Hornsby Ku-Ring-Gai Hospital Stage 2 – State Significant Development Project (SSD 8647)

Response to Submissions Report 2
NSW Health Infrastructure
12 April 2018

Response to Submissions Report – SSD 8647 – HKH Stage 2 Redevelopment

Project Number: **NET-AR-S2-1021**

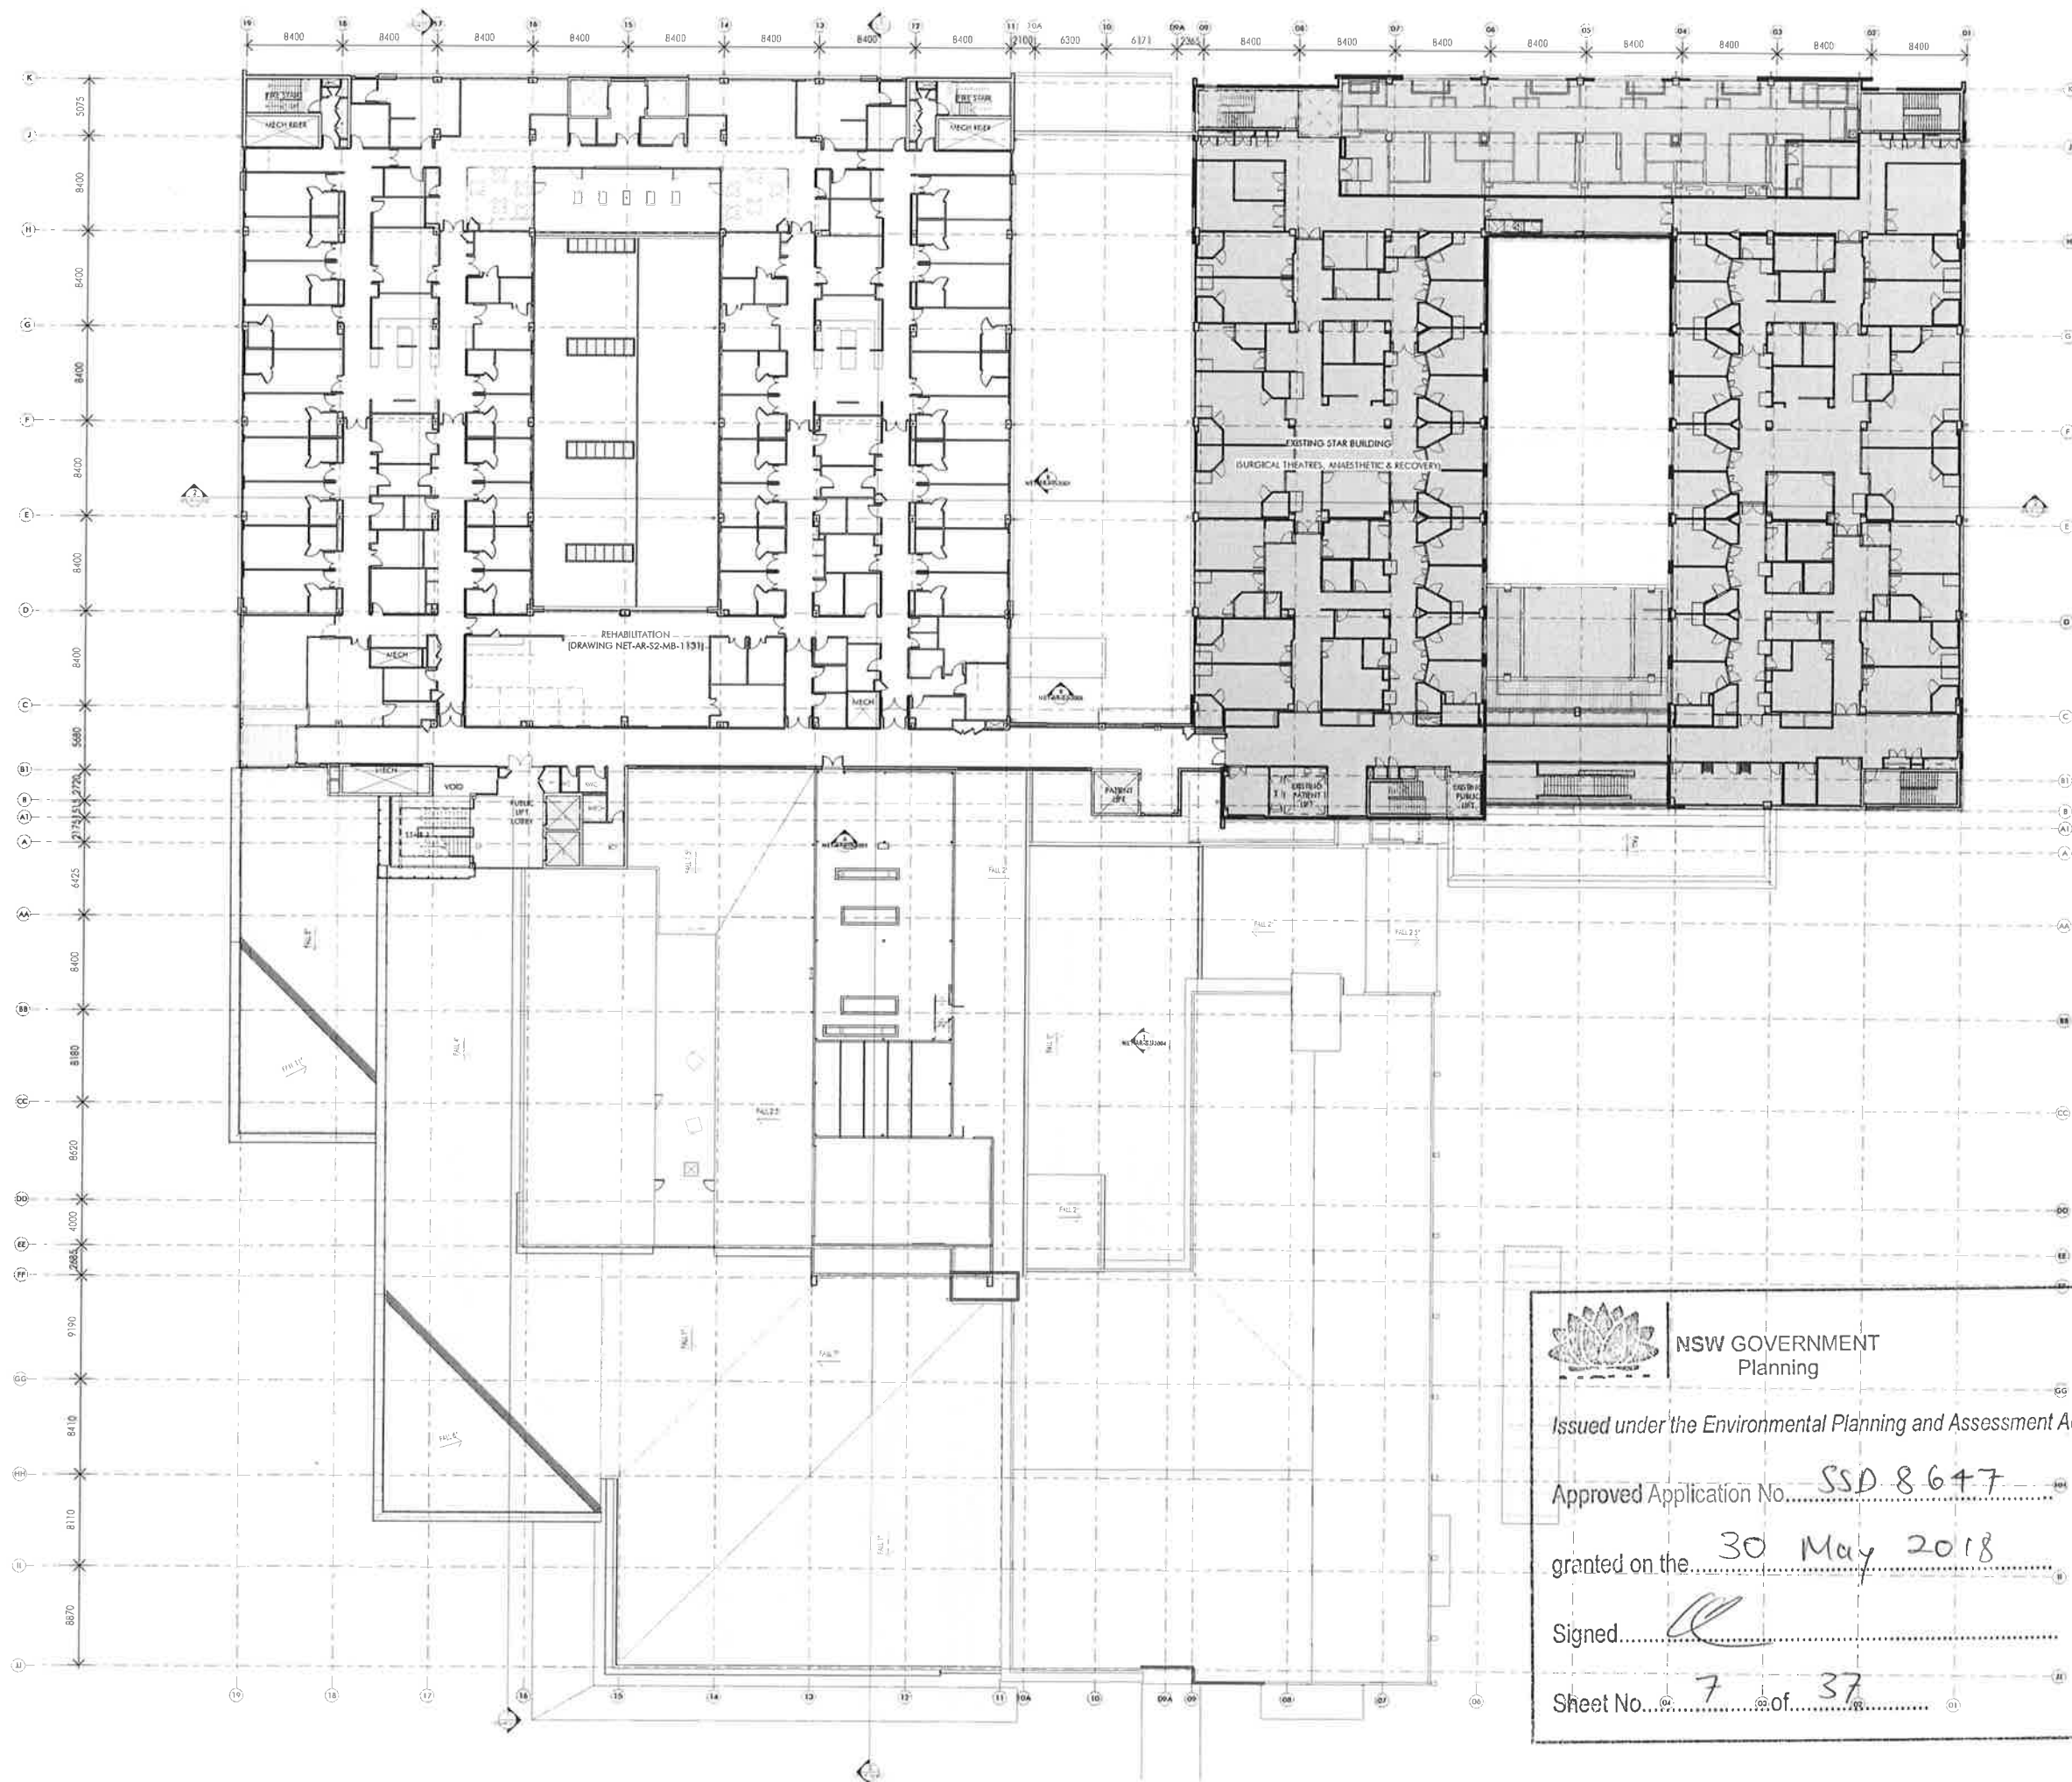
3.8	Department of Planning and Environment	The 'Level 2 – Overall Plan' (drawing no. NET-AR-S2-1021 Rev 4) includes the 'paediatric IPU' and 'paediatric outpatient unit' which is partially located above the approved medical imaging building. It is understood from the EIS that the paediatric unit was approved under Part 5 along with the medical imaging building. Please clearly indicate on plan which elements of the paediatric unit are subject of this application.	Please refer to Appendix 7 showing mark up of area subject to the separate approval.	Appendix G – Separate Approval Mark-up
		Architectural Plans
